# City of Albuquerque

November 5, 1991

RE: DRAINAGE PLAN FOR CENTRAL/AIRPORT BUSINESS PARK, RECEIVED  
OCTOBER 31, 1991 FOR BUILDING PERMIT APPROVAL, (K-10/D21A)

GRADING AND DRAINAGE PLAN - DETENTION POND ZANIOS FOODS

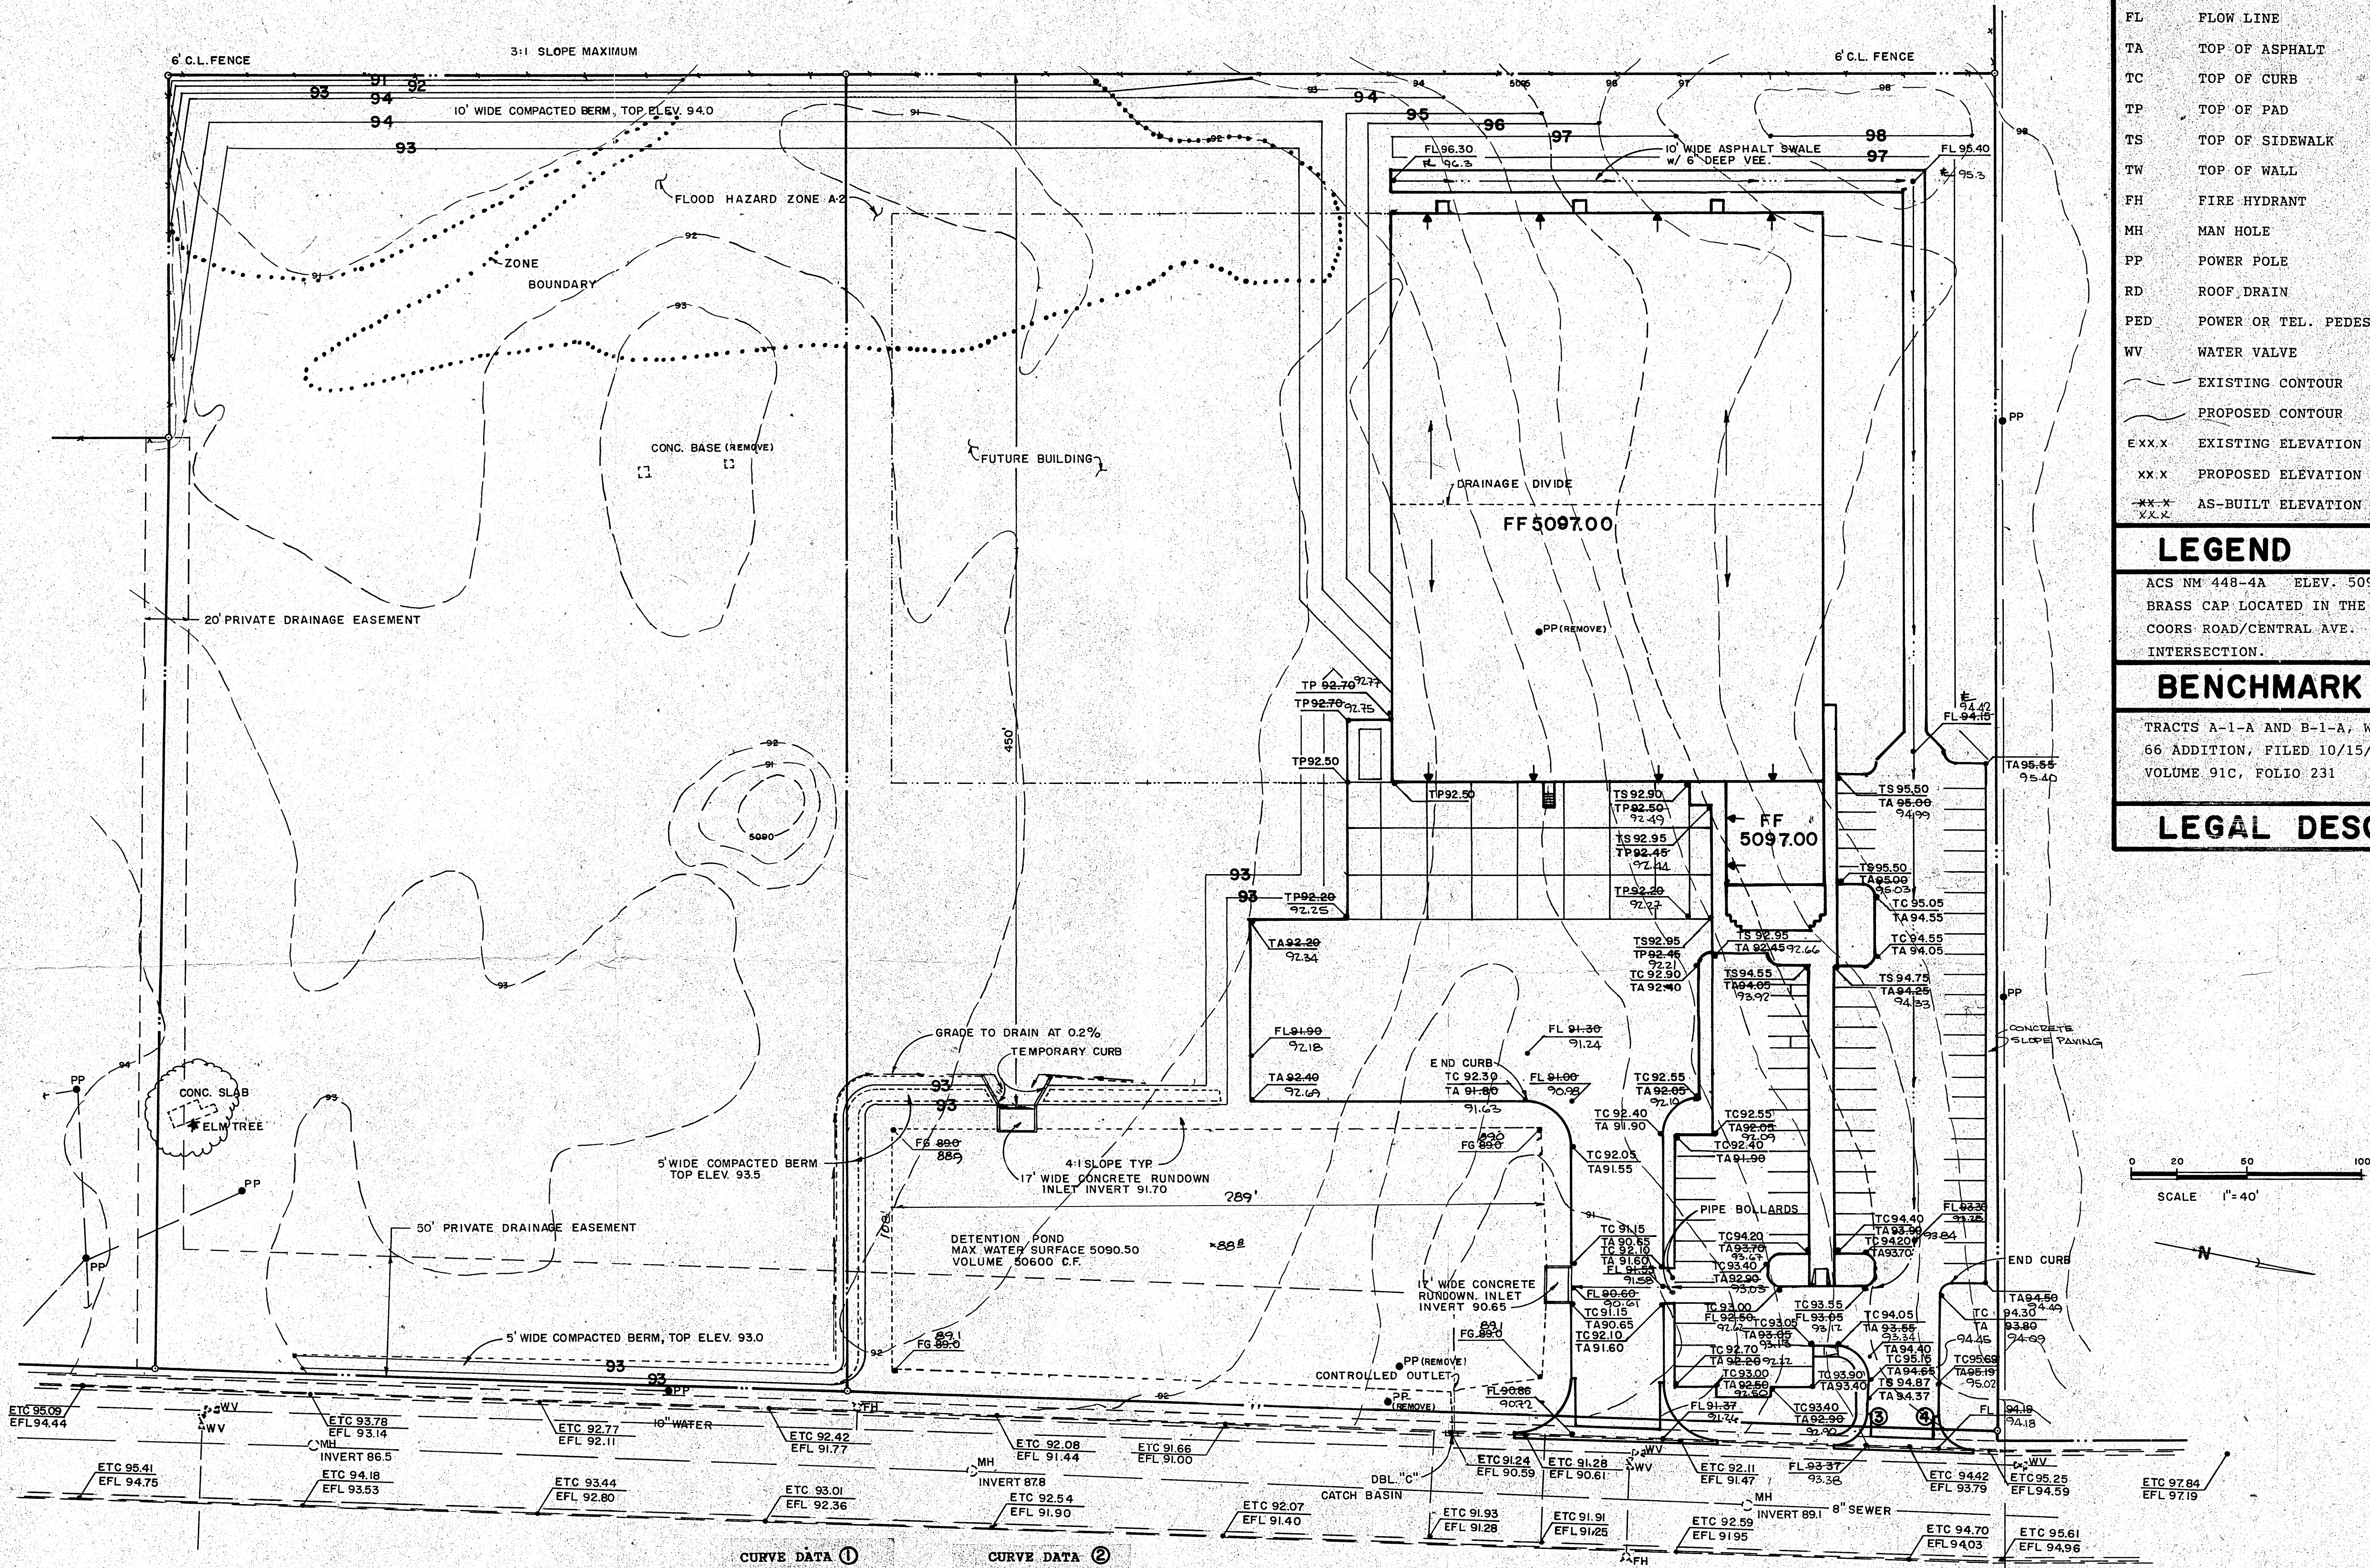
1. As you know, there are two phases involved in this project, the first phase involves retention ponding, and the second phase involves detention ponding with on-site modifications when the storm drain is in place. Your submittal shows both phases together. The problem I am having with this submittal is separating the phasing for the construction improvements. In order to clear this up, I feel that a Phase 1 plan should be on a separate sheet from the Phase 2 plan. This will make Hydrology's review much clearer and provide your clients with a clear understanding on the construction requirements required during the different phases.

2. Please provide a legend that designates the impervious areas.
3. Where will the portion of the roof and alley at the southwest corner drain to?
4. The minimum street grade to drain asphalt paving is 0.5%. Is this the case?

5. You should consider a concrete valley gutter along the swale of the parking lot. The concrete gutter will protect your asphalt paving for a longer period of time and reduce your clients maintenance cost.
